TITLE
FLOOR PLAN

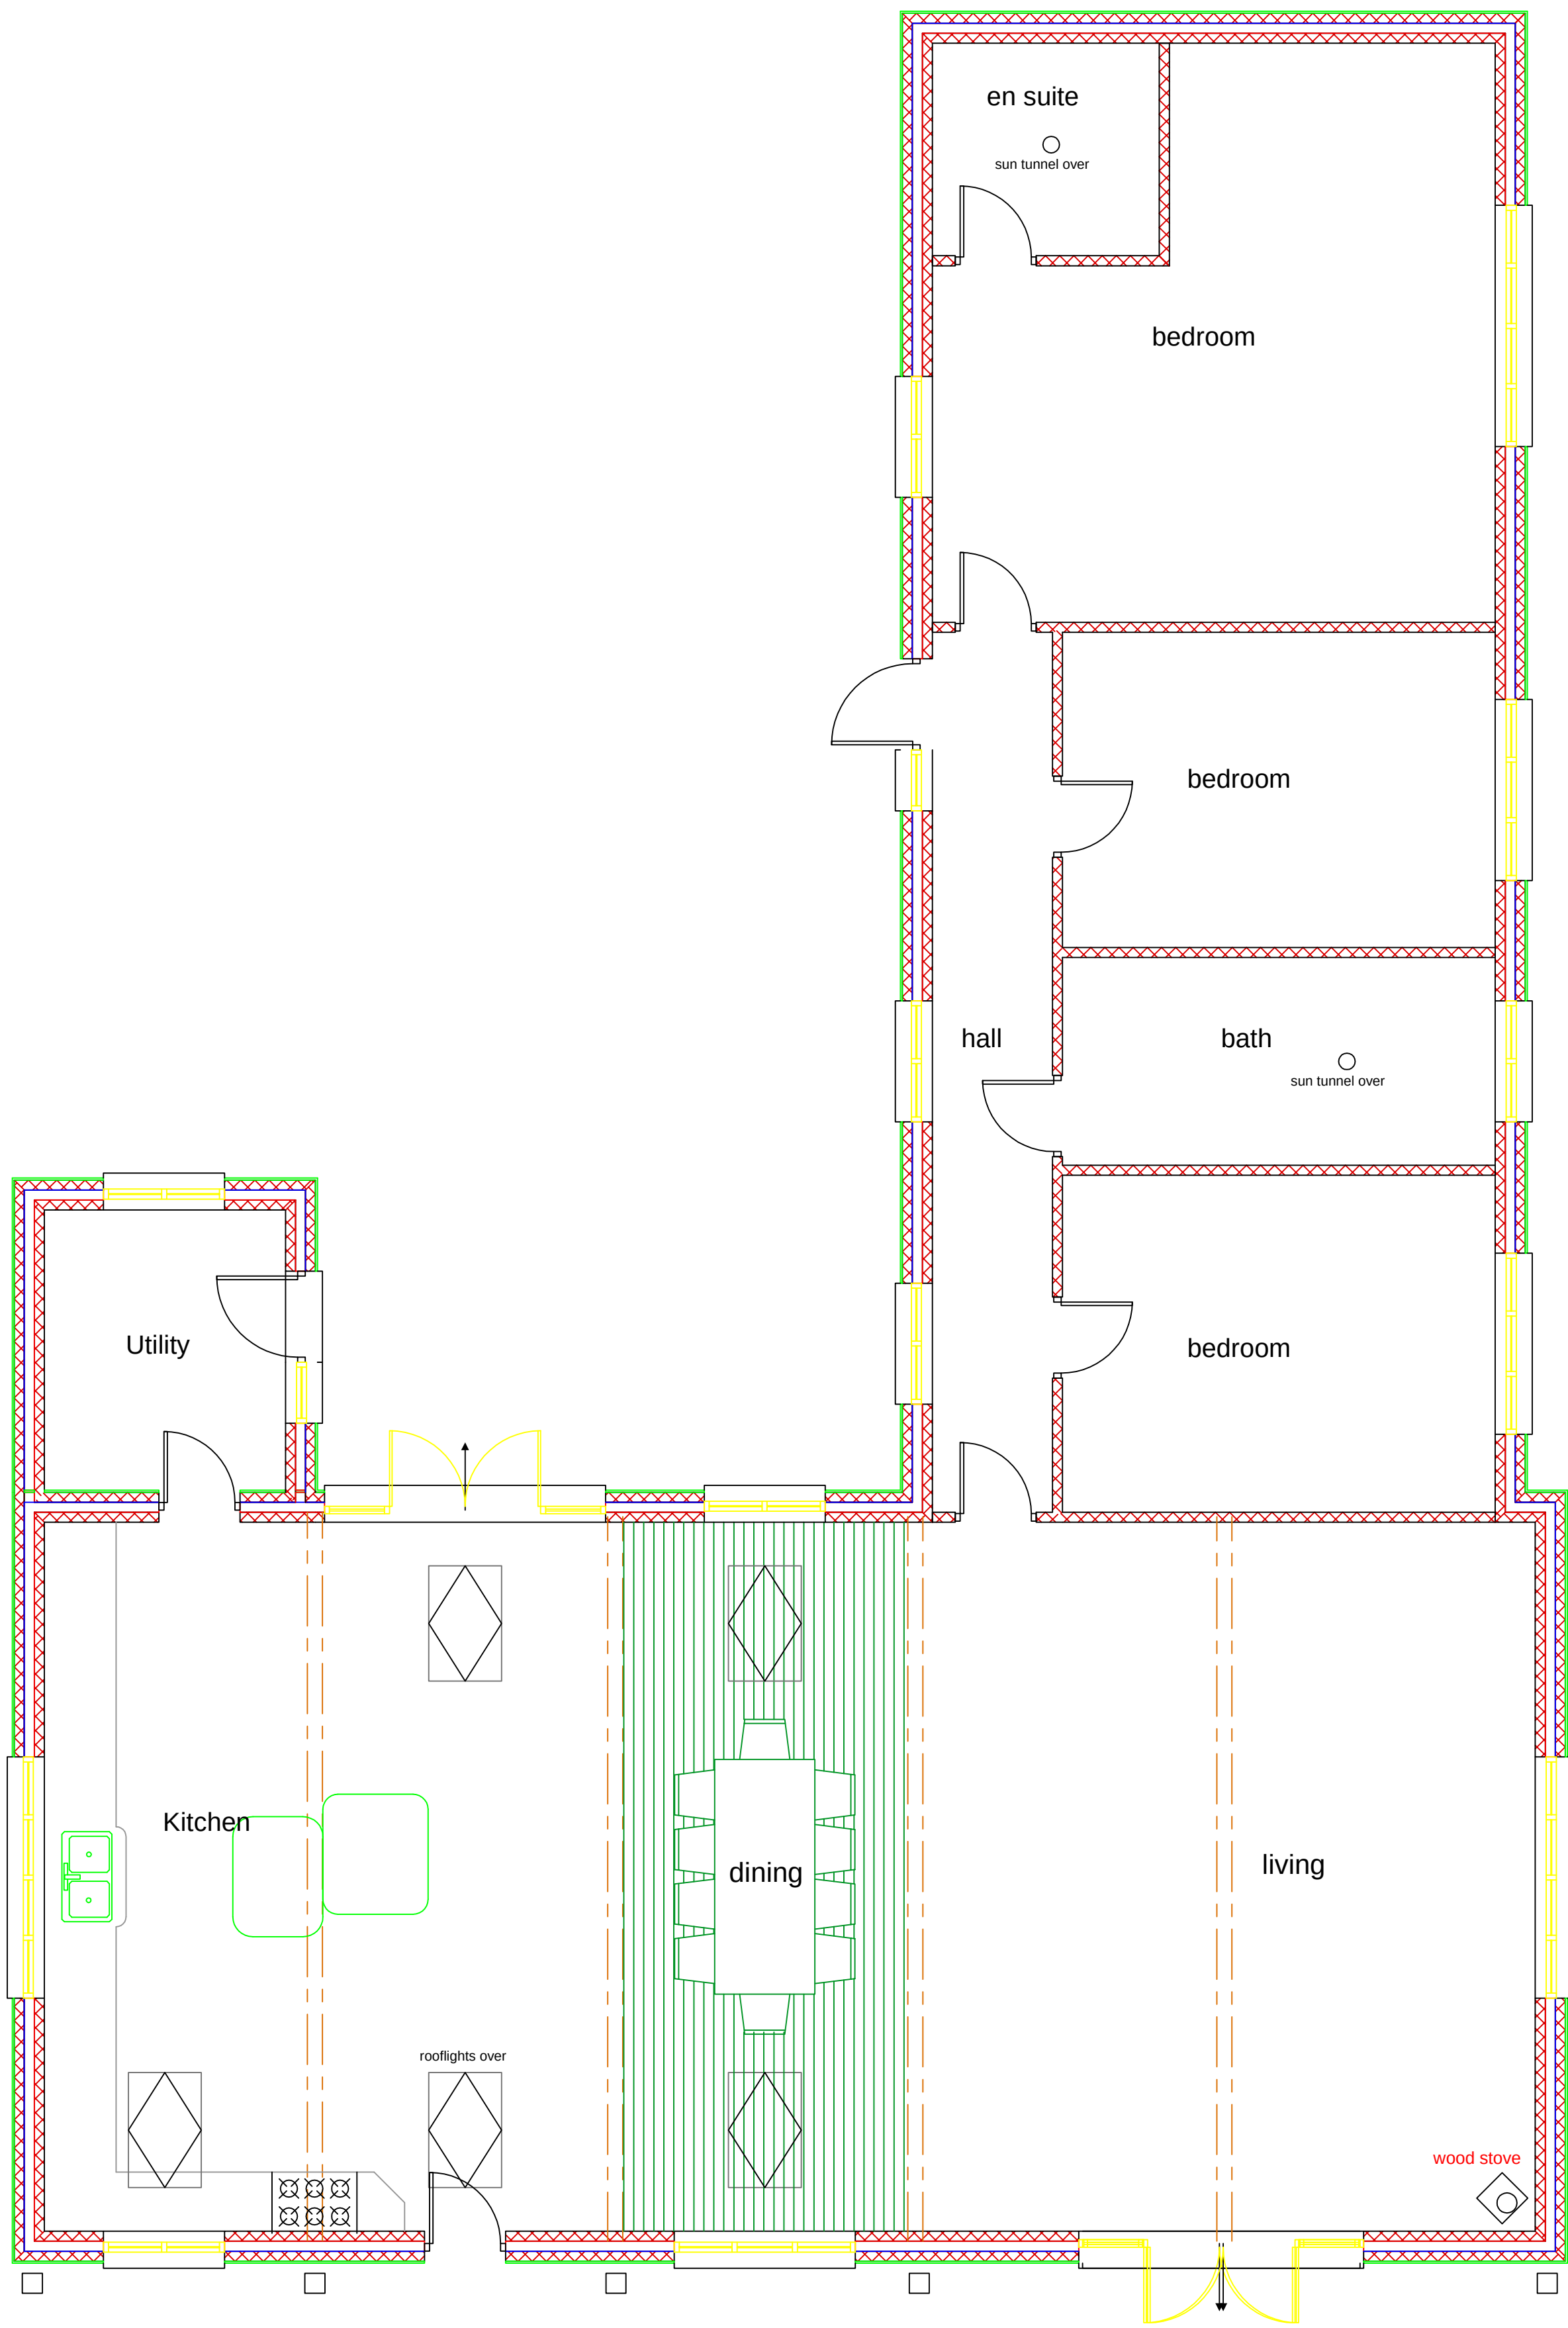
The size of hardstanding in a comparison with an approved doubled and urbanisation of this area is not desirable (happening).

As such it would be helpful if the impact is at least softer.

'It is unfortunate that such a large area appears to be proposed for hardstanding; it covers the entire width of the plot and would potentially urbanise the curtilage. Could the hardstanding either be reduced in size or designed so as to not look so suburban in character? If minded to approve the application, could this issue be dealt with by way of a landscaping condition?'

Parking needs to be close tot he front of the house for disabled access
i have significantly reduced the width of the hardstanding and trust that this will suffice, if not i am happy with a
condition
